Our ref: HMS ID 11586

Advice on Environmental Impact Statement – State Significant Infrastructure

Proposal: Mount Piper to Wallerawang Transmission Project

Major Project reference: SSI-70279722

Figure E.2c - Key project features

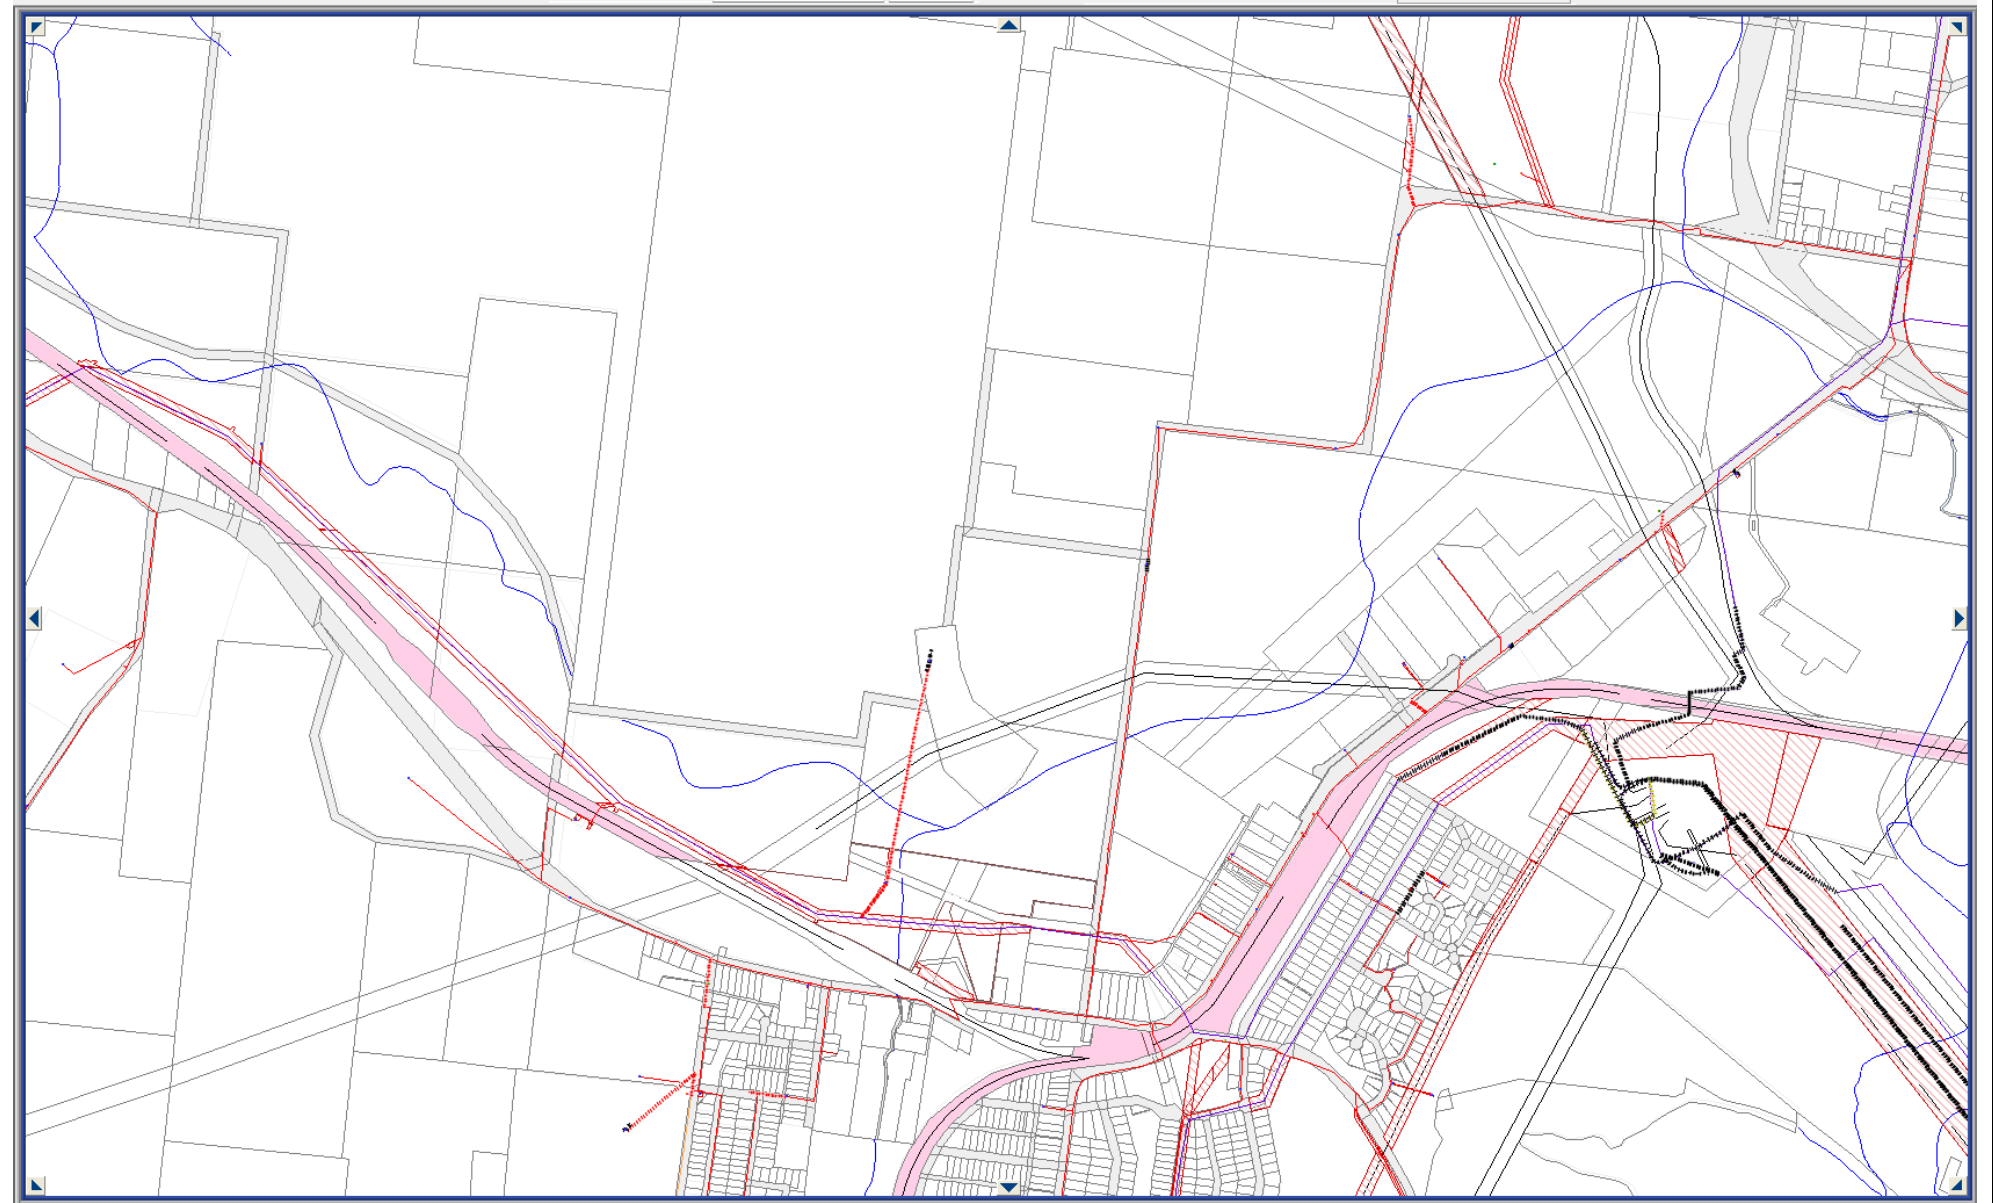
1. Please provide additional information on the following matters to clarify the potential impacts of the proposed works in relation to the *Wallerawang Rail Bridges over Cox's River* (SHR no. 01064):
 - a. Table 4-1 of the SoHI states that the nearest proposed works to the SHR item is the construction of a transmission structure 36m to its north, however Table 6.5 of the NVIA indicates that works are anticipated to include vibratory rolling, excavation and piling between 0m and 6m from the item.
 - b. The SoHI states that the access route which runs under the bridges will be limited to light vehicle usage and does not reference any proposed upgrades to this access route, however Figure E.2c of the EIS indicates that this track will be upgraded and widened.
